TO: New Home
ATTN: Derek Lindaman
PROJECT #: 21-2967-GL-A(37-WB)
PAGE: 1 of 1
DATE: October 6, 2023
LOCATION: Lot 37 Woodbridge South
PLAN REF: Plan 01 Garage Left by AJ Designs
Project# 21-2967-GL

THE FOLLOWING CHANGE(S) OR PROPOSED CHANGE(S) LISTED BELOW ARE DEVIATIONS OR CLARIFICATIONS FOR THE ABOVE REFERENCED PLANS:

S-1.2

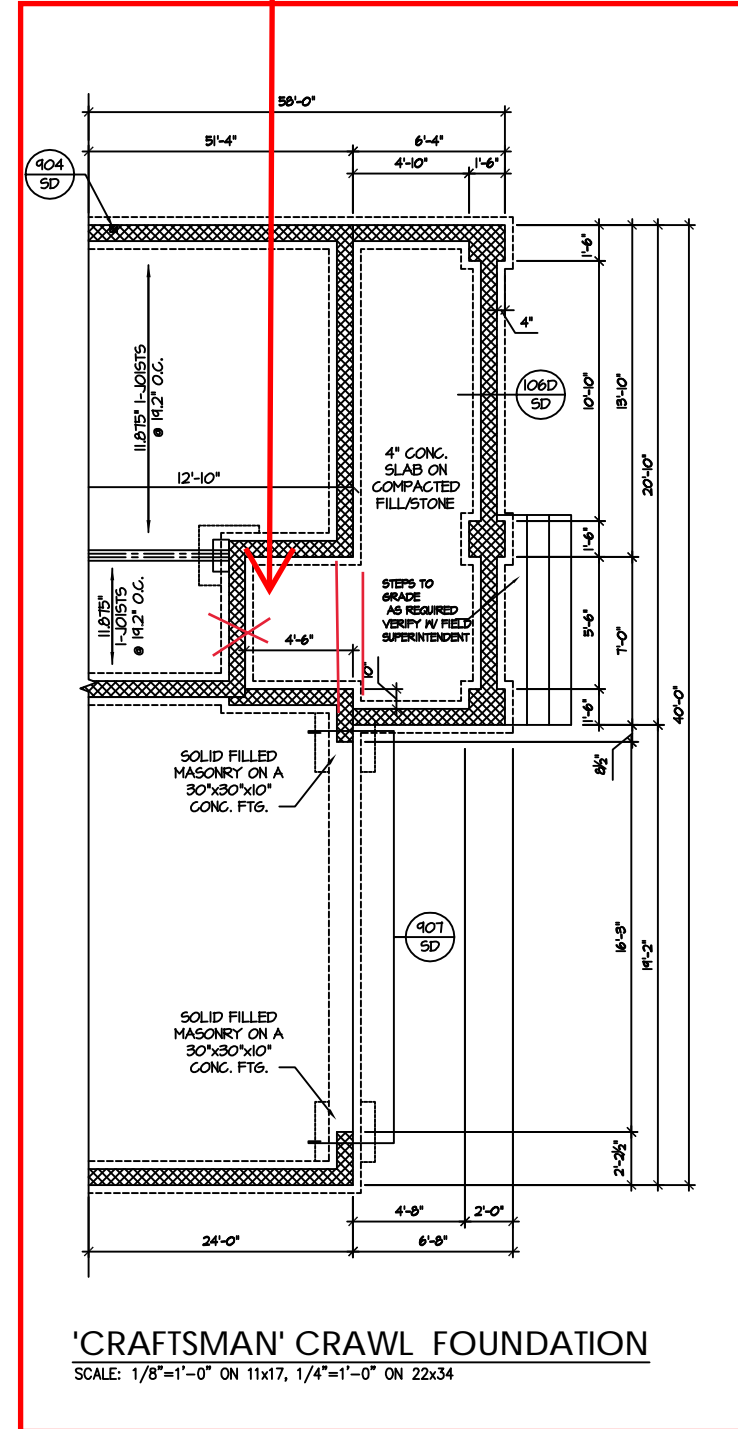
Extended LVL and Missing Footing: The original plans call for a footing to be poured under the Garage slab below the stairs. Per information provided by the builder the footing mentioned above was not poured. The footing being poured caused the (2) 1.75 x 14 LVL to not be able to bear on that footing.

Response: The footing not being poured and the (2) 1.75 x 14 LVL are acceptable providing the (2) 1.75 x 14 LVL be extended to the short (2) 1.75 x 14 LVL and bear directly on the foundation wall. Also, the short (2) 1.75 x 14 LVL shall be hangered to the extended (2) 1.75 x 14 LVL with Simpson HU416.
